CITY OF PORTLAND BUILDING PERMIT

Job ID: 2010-12-93-ALTR

has permission to Change Use from a Two to a Single Family Residence/ Exterior Deck Construction.
provided that the person or persons, firm or corporation accepting this permit shall comply with all of the provisions of the Statues of Maine and of the Ordinances of the City of Portland regulating the construction, maintenance and use of the buildings and structures, and of the application on file in the department.

Conditions of Approval:

FIRST FLOOR

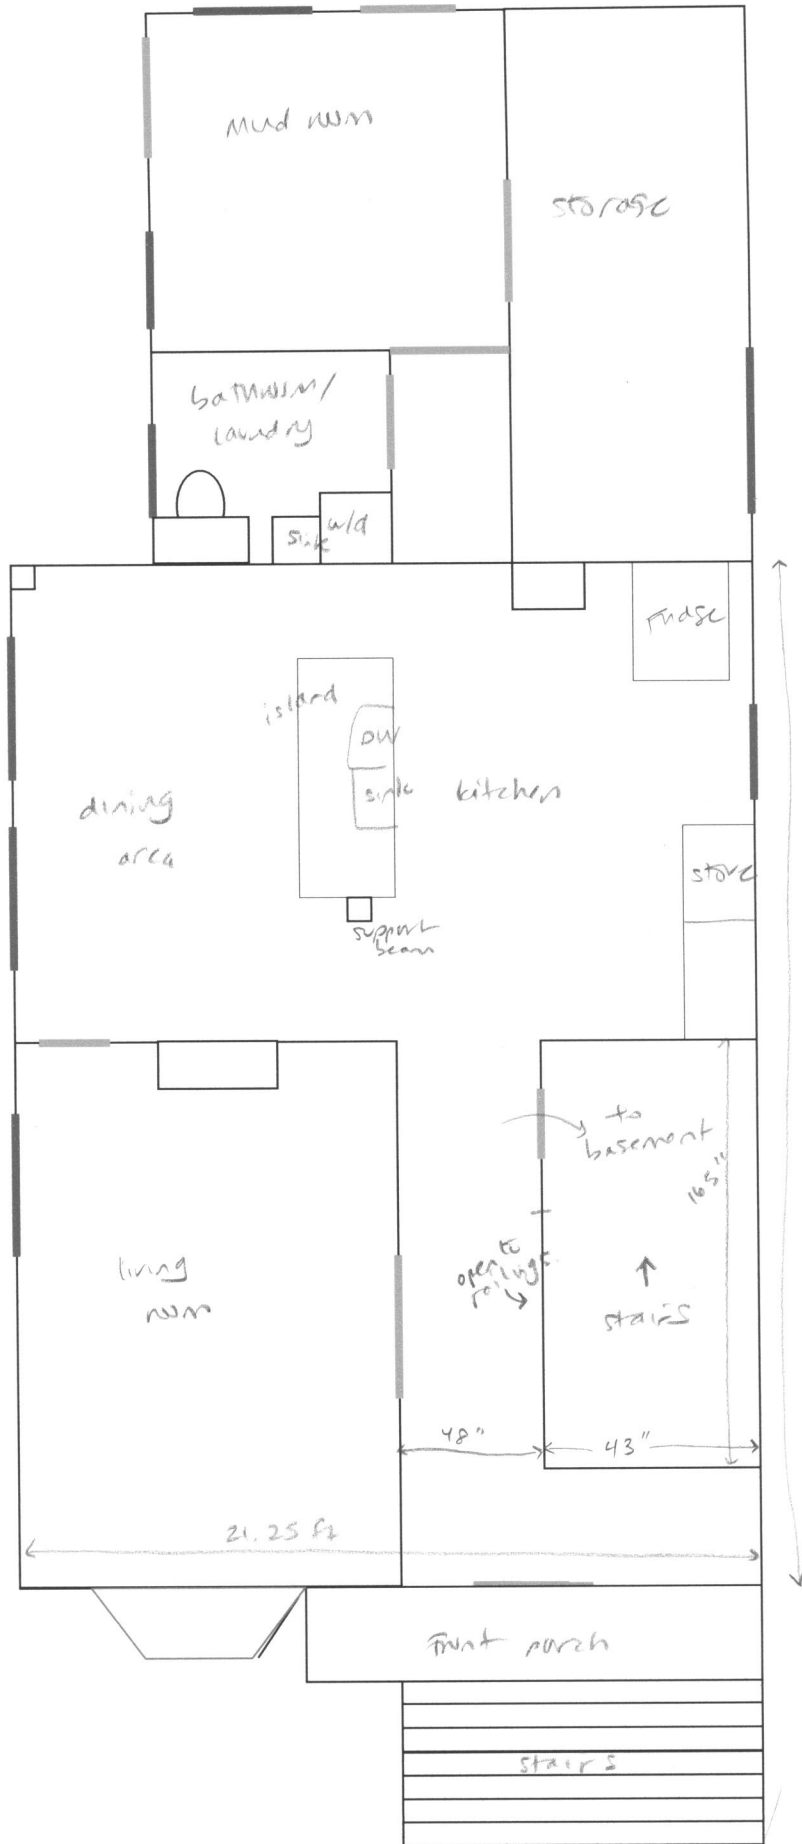
5. A graspable handrail (34-38 inches in height) shall be provided on at least one side of each continuous run of treads or flight with four or more risers. Fall protection from exterior decks may be required if floor joist are at or above thirty (30) inches from grade.

Back deck - Replaced old structure, same footprint

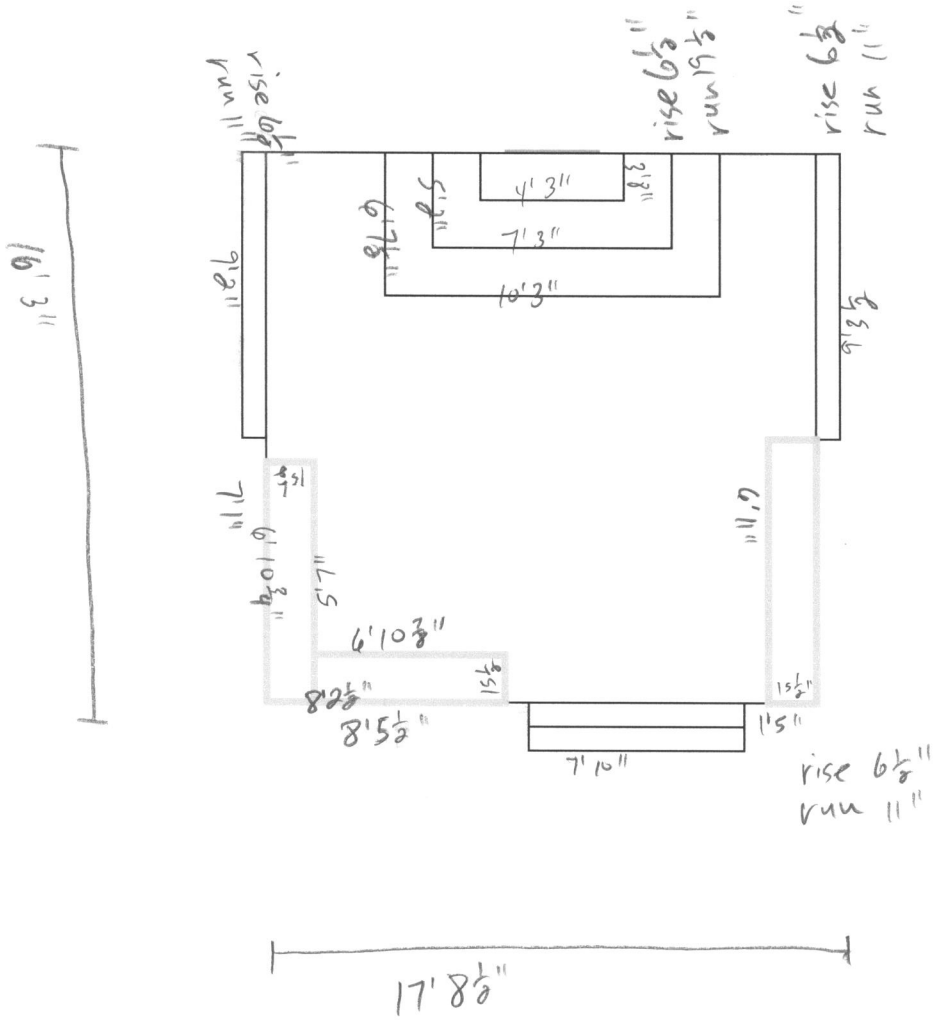
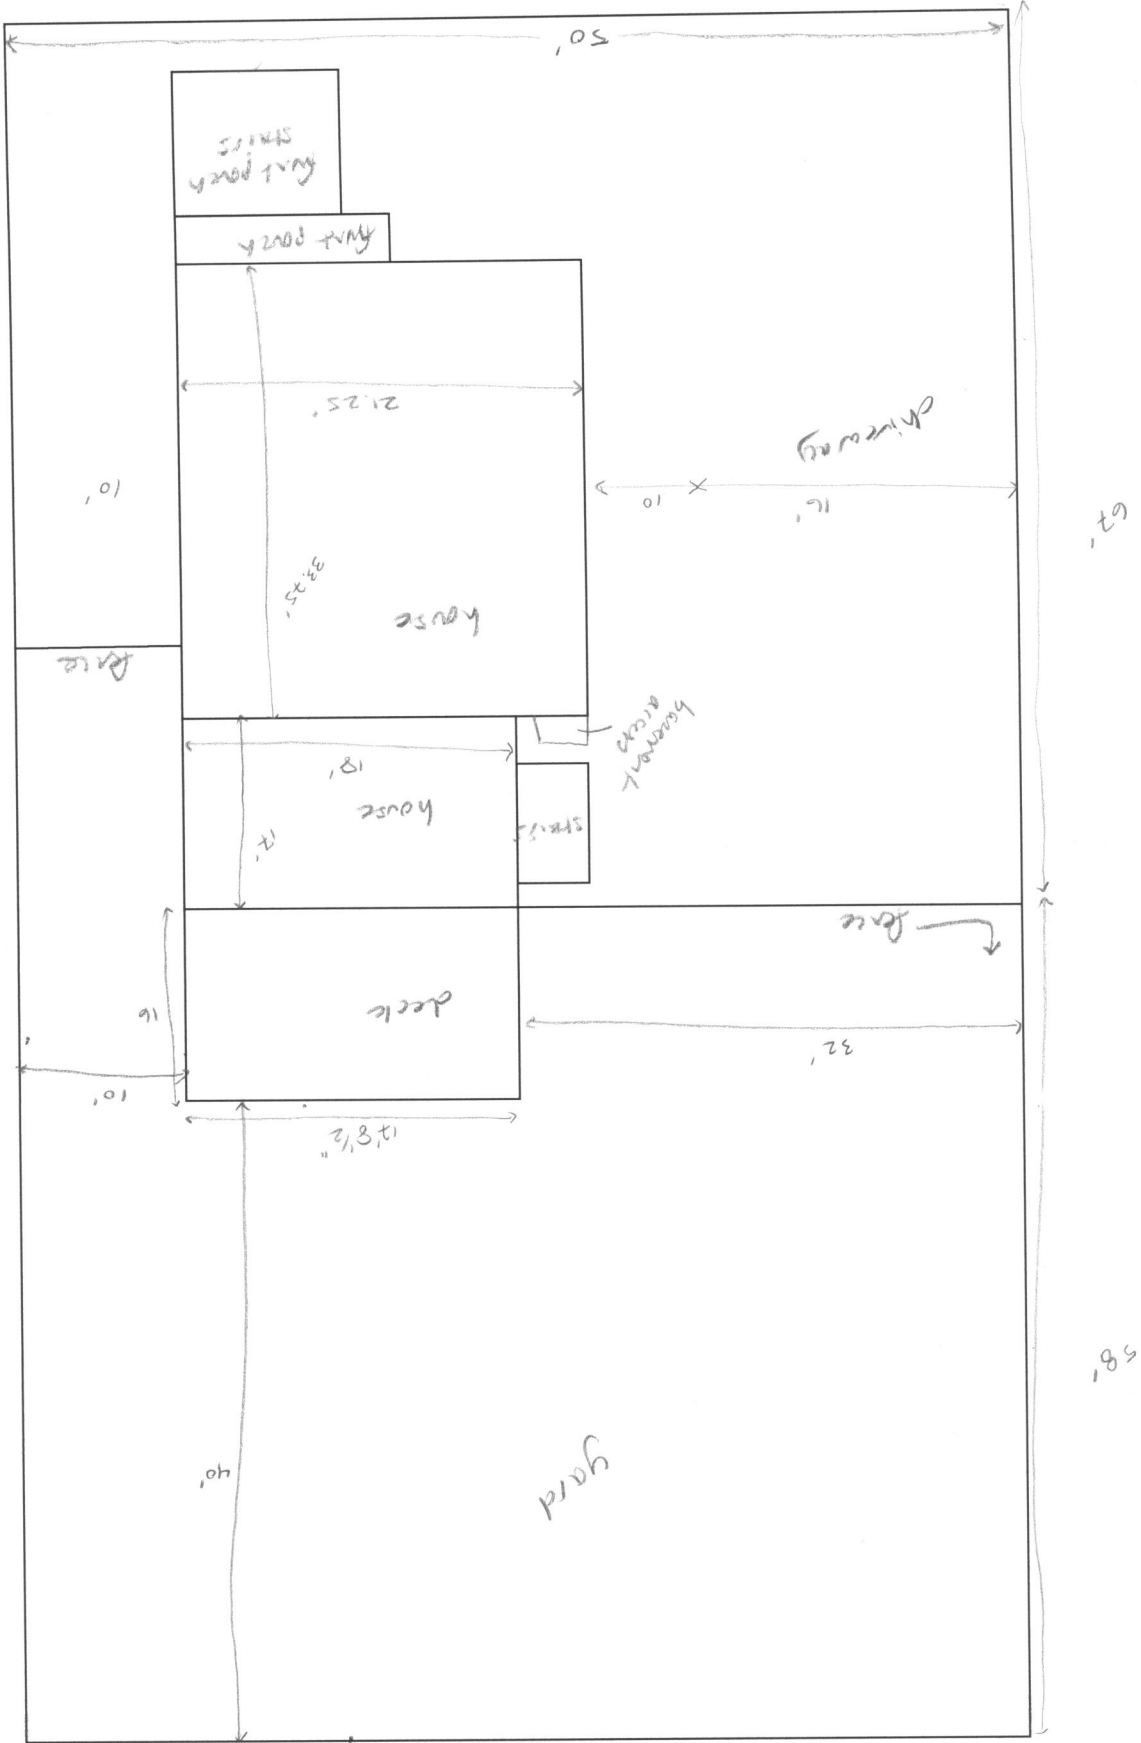
2. The basement is NOT approved as habitable space. A code compliant 2nd means of egress must be installed in order to change the use of this space.
3. The existing deck shall be inspected for adequate fasteners and bearing for spans, and modifications may be required.

8. R311.5.1 Attachment. Exterior landings, decks, balconies, stairs and similar facilities shall be positively anchored to the primary structure to resist both vertical and lateral forces or shall be designed to be self-supporting. Attachment shall not be accomplished by use of toenails or nails subject to withdrawal.
